# CITY OF ALBUQUERQUE

June 14, 2013

**Re: Dream Style, Grading and Drainage Plan (F16/D005K)  
Tract 4A2 Correction Plat of Tracts 4A1 & 4A2  
Grading Plan Engineer's Stamp Date 06-11-2013  
Drainage Management Plan date 05-16-2013**

DreamStyle
GRADING PLAN
ALBUQUERQUE, NM
PROJECT #1817

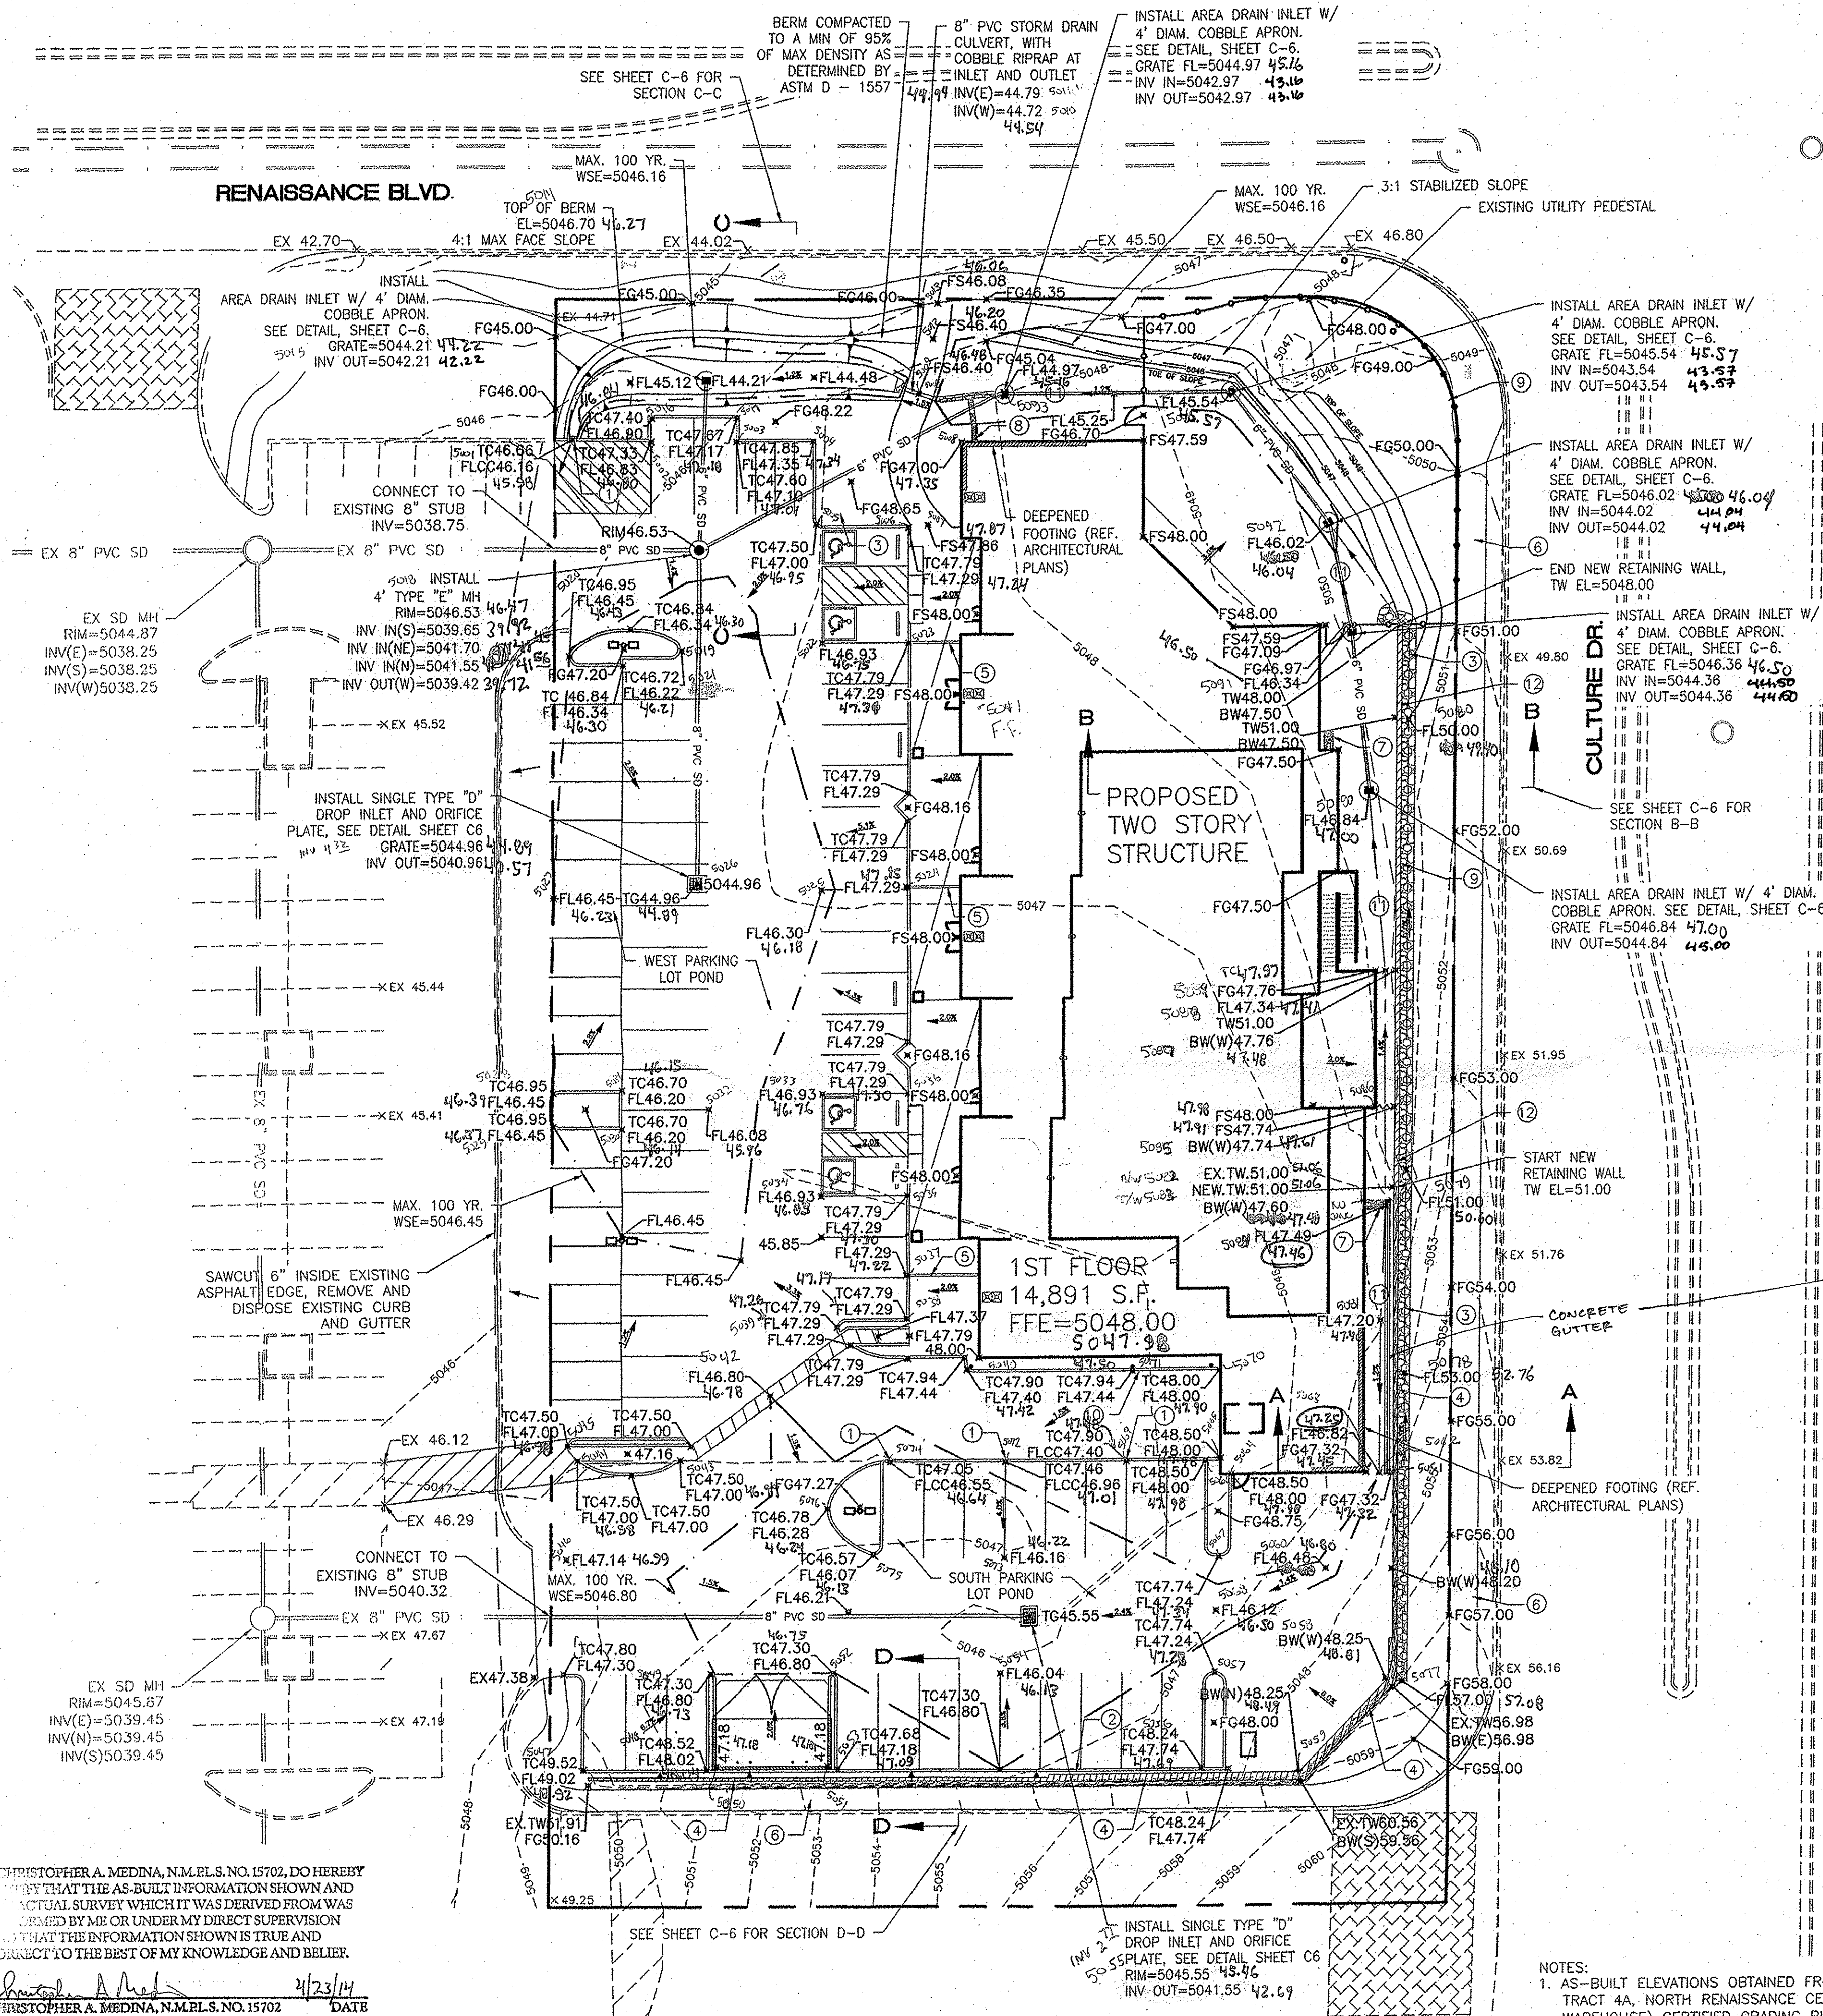
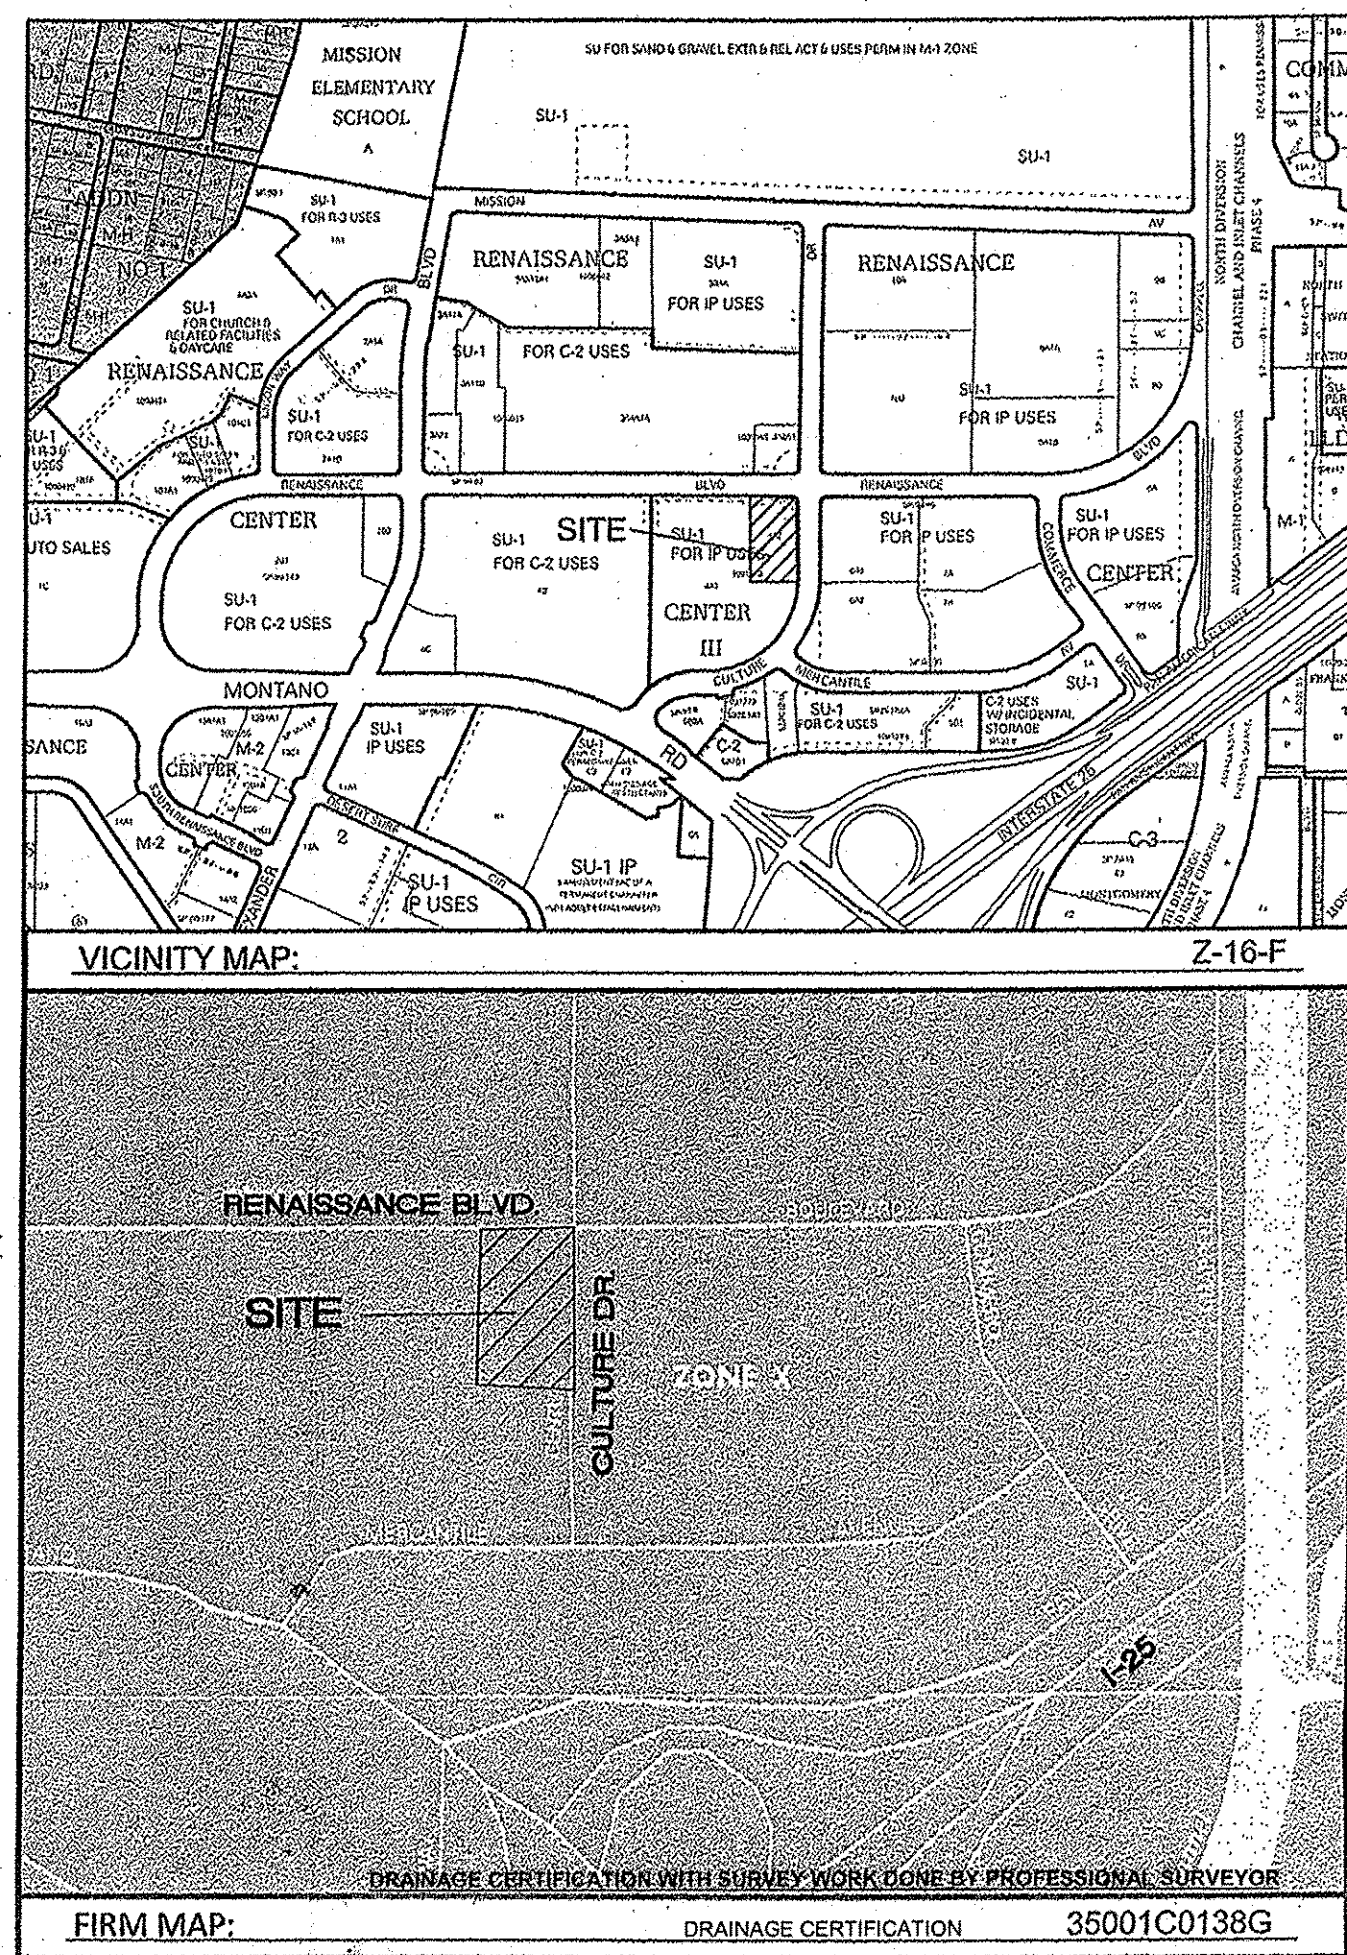
1. FEMA Map is not clear. Please add the location of the site on the map.
2. Clearly indentify the existing and proposed retaining walls. The Legend does not match the plan. Provide Top of wall and bottom of the wall elevations.

5. Darken the building boundary.
6. Please double check the area east side of the building. How is the runoff draining around the building? At one location bottom of the wall is at 48.67 and finished floor elevation is at 46.50.

COBBLE DRAINAGE SWALE DETAIL
NTS

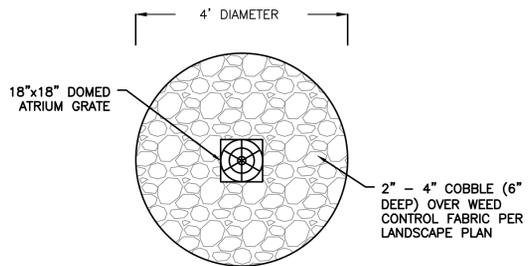
3. Please include a detail for the 1'x3' metal scupper in the wall.
4. Cobble apron is called out to be 5'x5' on sheet C2 and the detail on sheet C-6 is 4'x4'.

SECTION C-C
NTS

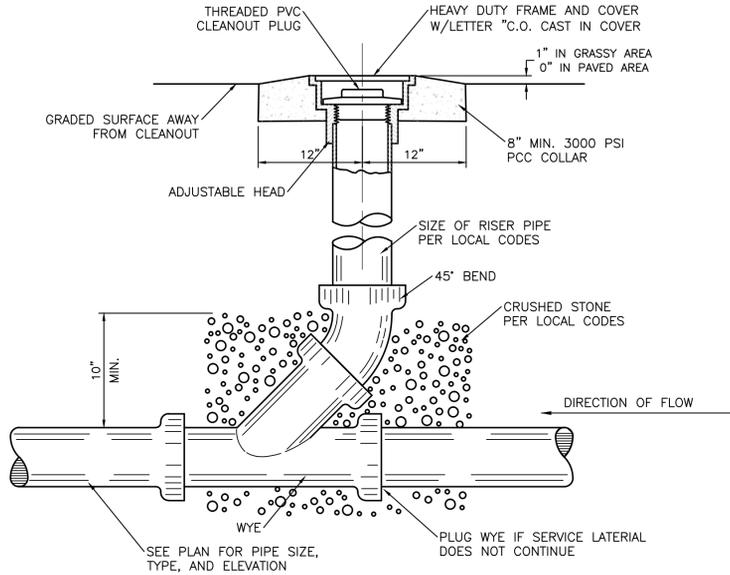
9. Please include removal notes for the exiting curbing on the west side of the project?
10. Section C-C on sheet C6 includes curb & gutter in the parking area. Will the gutter be depressed?

TYP. ORIFICE PLATE DETAIL
NTS

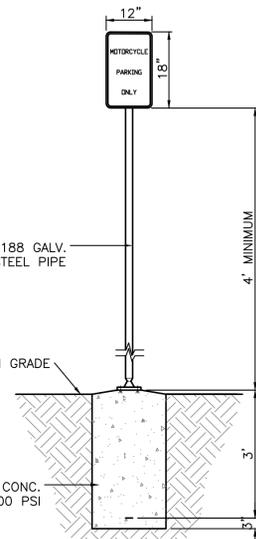
7. The runoff appears to overflow into Renaissance Boulevard on the north side of the project.
8. The orifice plat detail provided is for drop inlets. Please provide an orifice plate detail for manholes.
